From: Mundy, Ben - Oxfordshire County Council <Ben.Mundy@Oxfordshire.gov.uk>
Sent: 25 April 2024 12:17
To: Katherine Daniels; DC Support
Cc: Transport CDC Minor
Subject: FW: Planning notification for application reference: 24/00725/DISC
Attachments: eCon_(5).pdf

Condition 3 (Construction Traffic Management Plan) Objection

Condition 4 (Site Access Scheme)

A-030-COND 15

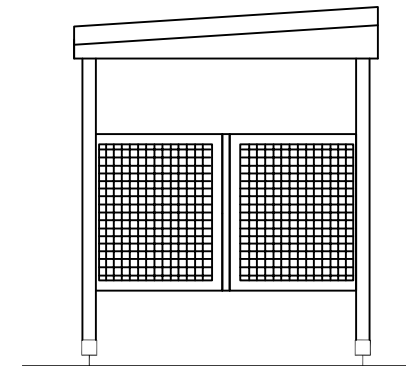
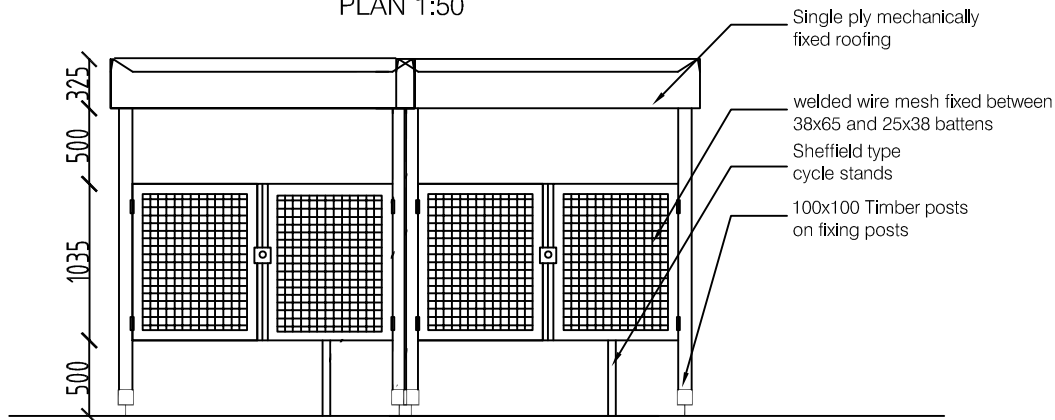
Residential cycle parking infrastructure must be fully enclosed to ensure cycles are protected from adverse weather conditions.

**LAND ADJACENT COTFIELD HOUSE**  
**OXFORD ROAD BODICOTE**  
**CONSTRUCTION TRAFFIC MANAGEMENT PLAN**  
FOR PLANNING CONDITION 3  
MARCH 2023 A-030-COND3 1:500  
For Planning application No: 21/03947/F @A2

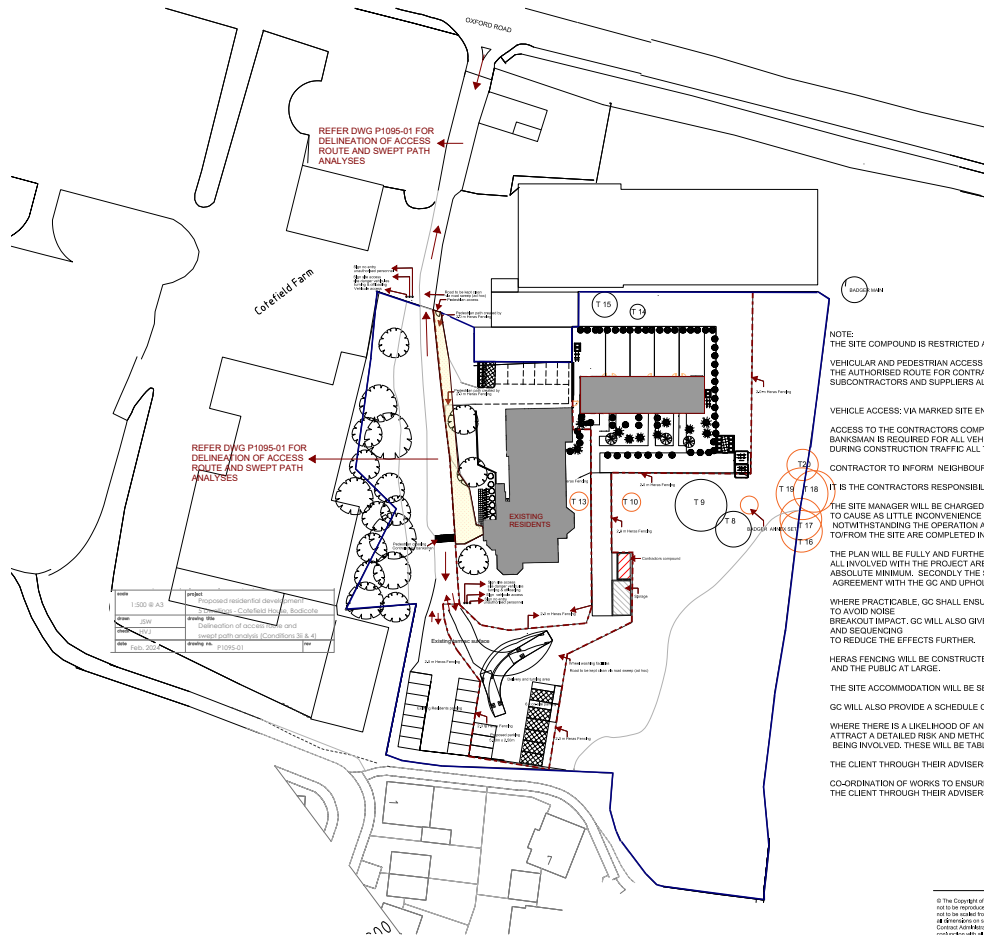
Routing of construction traffic and delivery vehicles is required to be shown and signed appropriately to the necessary standards/requirements. This includes means of access into the site, this should be shown on a map.

Delivery times must be added to the document and must avoid the times of 07:30-09:00, 15:00-16:00 and 16:30-18:00 to avoid school pick up / drop off and network peak hours.

The CTMP outlines that a mirror is to be installed to aid with egress from the site. The applicant must obtain a separate licence for this which has not been demonstrated within the application.
